P/153/21/RES & P/167/21/RES - Land South of Summer Lane

Please find enclosed updated plans and documents for formal registration on the above applications, made to positively respond to outstanding comments, particularly in relation to Appropriate Assessment (AA) and landscaping matters. For your ease, we have described in the table key updates to the plans and how they address comments raised.

ARUN DISTRICT COUNCIL P/153/21/RES

document number
10095-FPCR-XX-XX-DR-L-0016

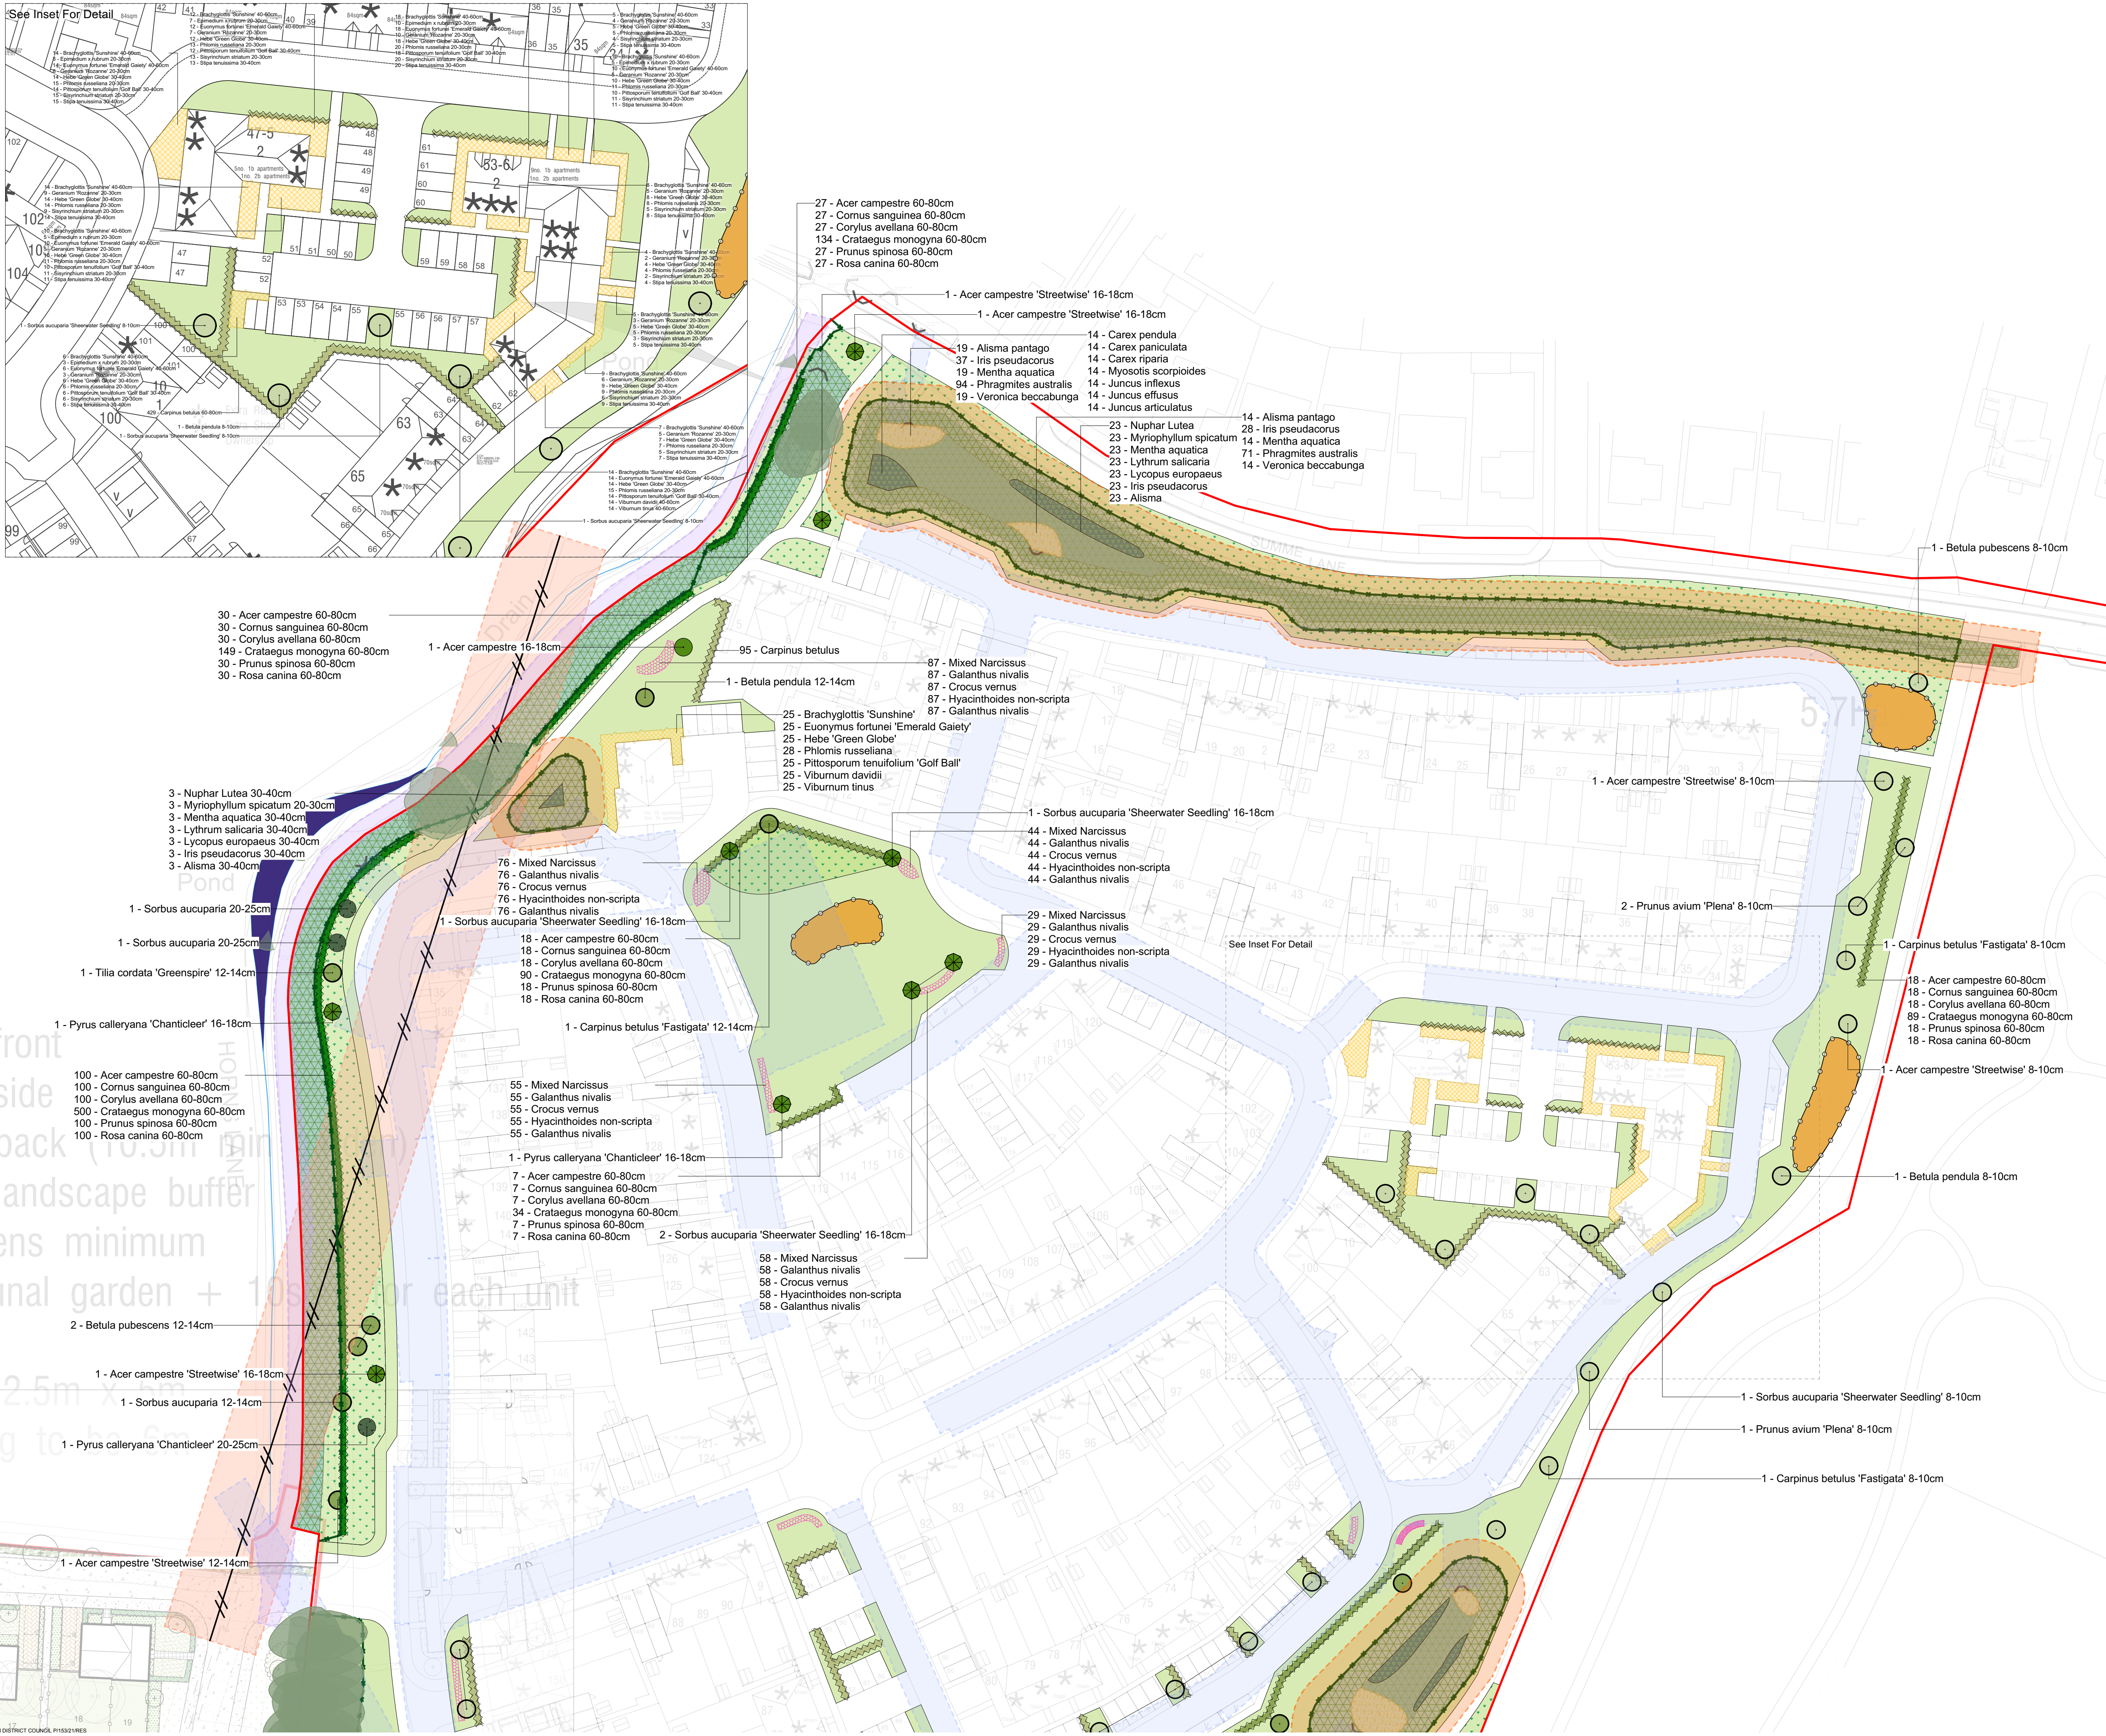
Area around the allotments should be planted with varying depths to create a more organic edge.	Please see 10095-FPCR-XX-XX-DR-L-0019 P03 from FPCR. Additional native shrub planting proposed around the edge to address comment.
Only one type of bulb proposed (daffodil) in the POS space. I think this could be better varied for pollinators.	Please see 10095-FPCR-XX-XX-DR-L-0016-20 P03 from FCPR.
Other
